REQUEST

Current Zoning: R-5 (single family residential)
Proposed Zoning: UR-2(CD) (urban residential, conditional)

SUMMARY OF PETITION

The petition proposes to allow up to 26 multi-family units on parcels that are currently vacant.

SITE PLAN

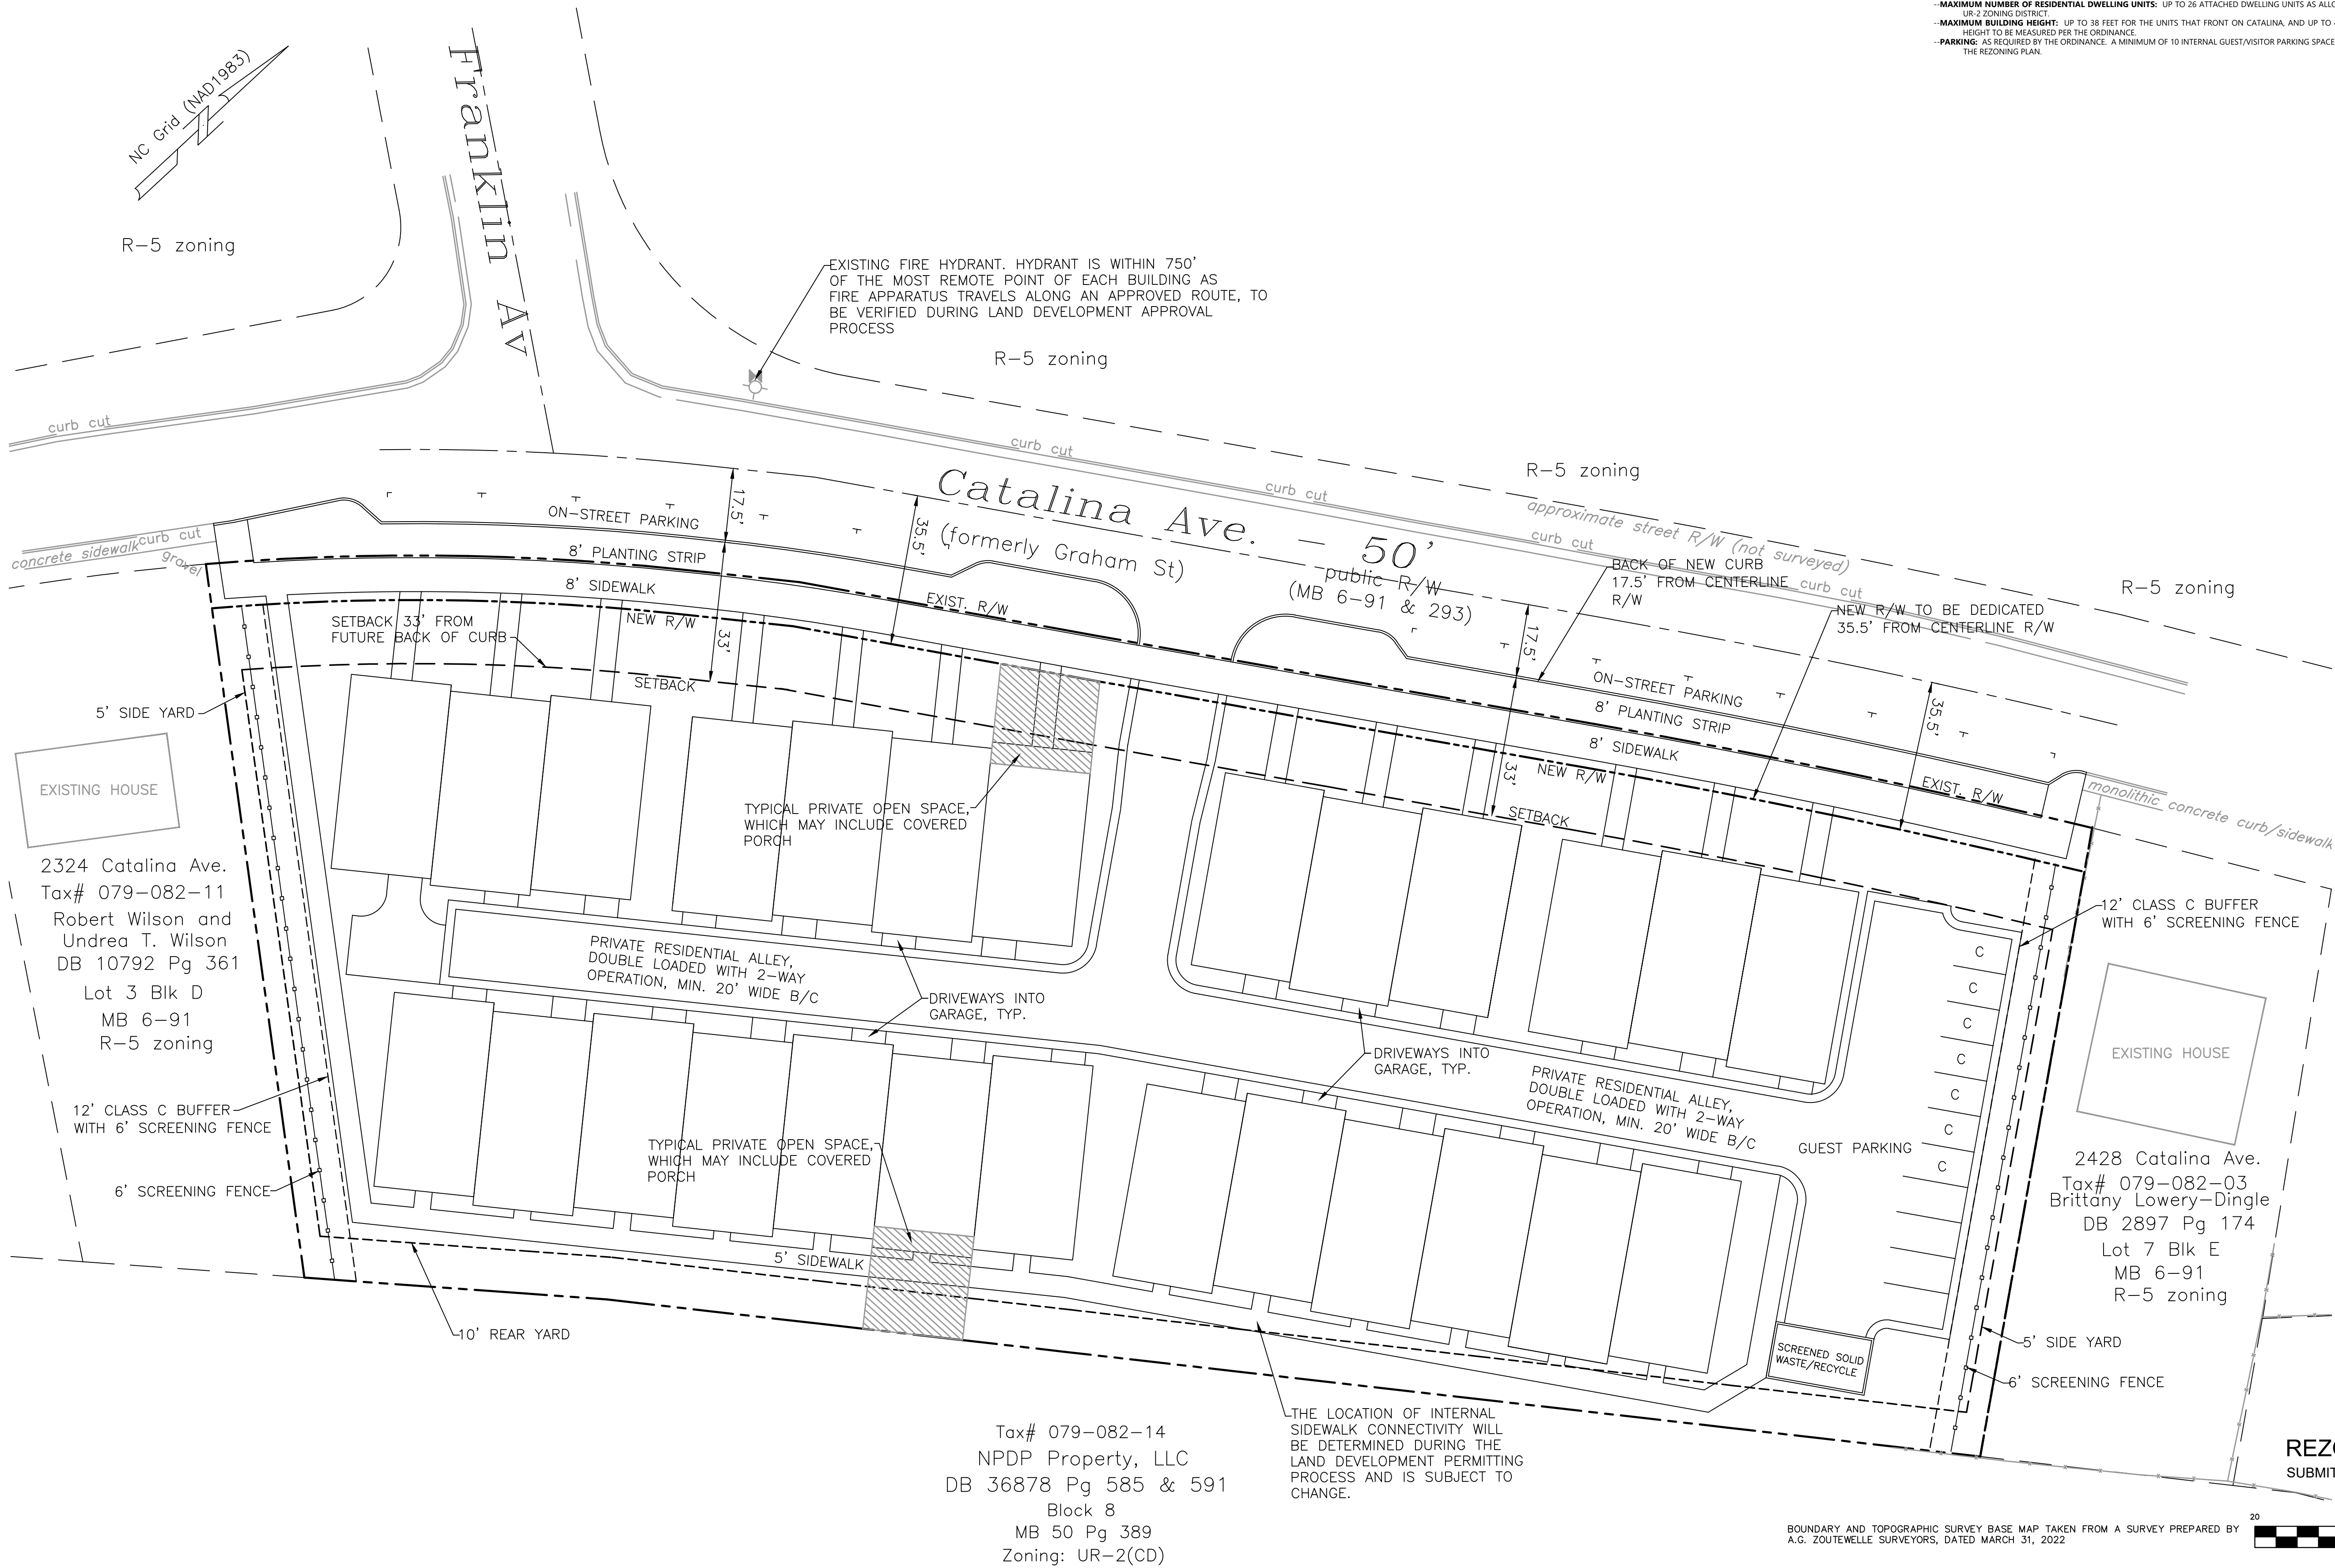
- ~~1. Revise the site plan so that no structures are located in the setback.~~ **Addressed**
 - ~~2. Relocate the proposed screened solid waste and recycling area so that it is not within the rear yard or 5' of the property to the rear.~~ **Addressed**
-
